From: [REDACTED]
Sent: 25 April 2018 16:13
To: Planning
Cc: [REDACTED] Mr. Paul Bicknell; Cllr. Andy Cooper; Cllr. Dudley Wensley
Subject: A/38/18/RES Manor Nursery, Angmering

Please find attached Objection to planning application
A/38/18/RES Manor Nursery, Angmering.

Whilst accepting the principal of development on the Manor Nursery site, SAV strongly **OBJECTS** to elements of this application. Specifically, in respect of the proposed main access route to the development via the High Street. The issues highlighted below have already been noted in the previous application A/51/14/OUT for this site, but in our view, have been ignored by the developer.

Status	DRAFT		Scale	1:250 @ A1
Drawn	BC	Checked	MS	Date APRIL 2014
Drawing Number	033/01			Revision A

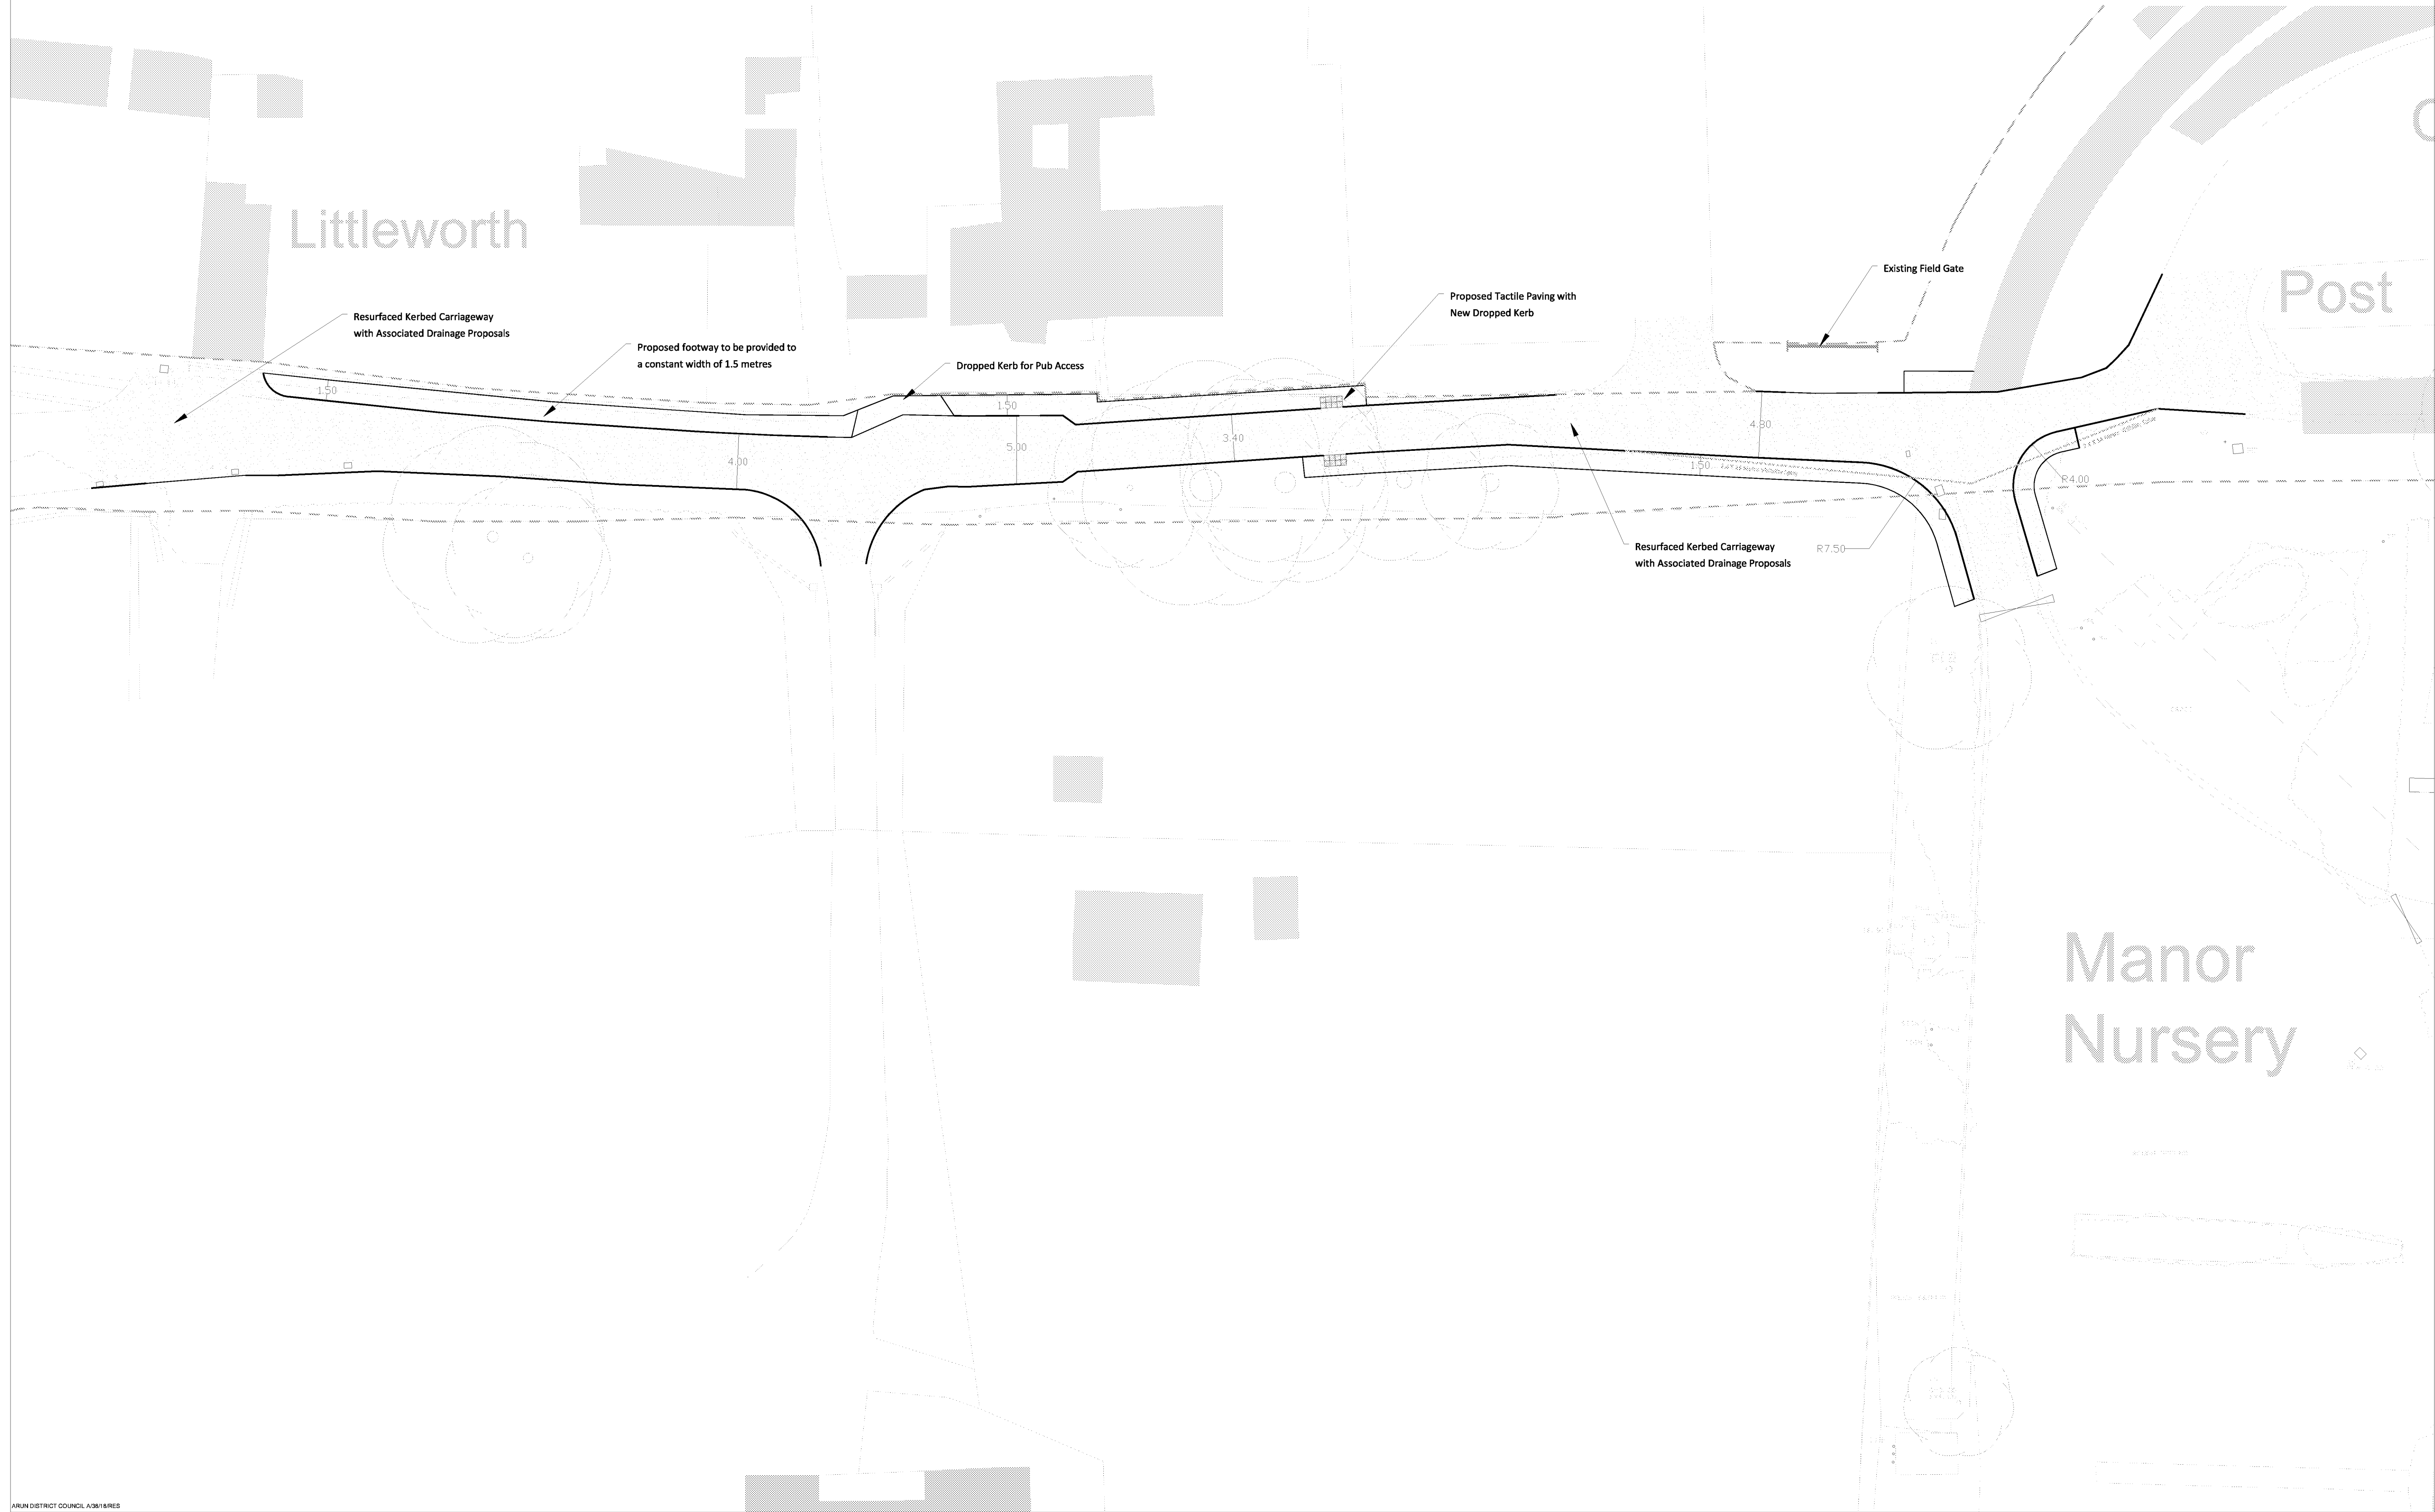
Inadequate Footways and footpaths: The latest plan provides additional detail on the widths of the proposed footpaths along High Street which clearly do not provide satisfactory standards of access for all users.

The applicant does not explain or give any reasons why the width of the proposed footpaths along the High Street are significantly less than that recommended by national guidelines, especially when you take into account that in most cases they are bounded on one side by walls or hedgerows, not verges which provide users with additional "elbow room".

The proposed design does not provide this. Instead, the current amenity value of the High Street will be irrevocably degraded by the proposed introduction of a "restricted" footpath width of between 1500mm and 1000mm, which compromise safety by not only requiring users to walk single file or step into the road to pass each other, but is not continuous and means users will have to cross and re-cross the road along its length.

The High Street access proposal provides no physical separation between the narrow footpaths and single track road, whereas Nanson's Lane was designed as part of the Masterplan specifically for that purpose, and therefore meets national guidelines for the safety of all highway users, specifically all non-motorised users.
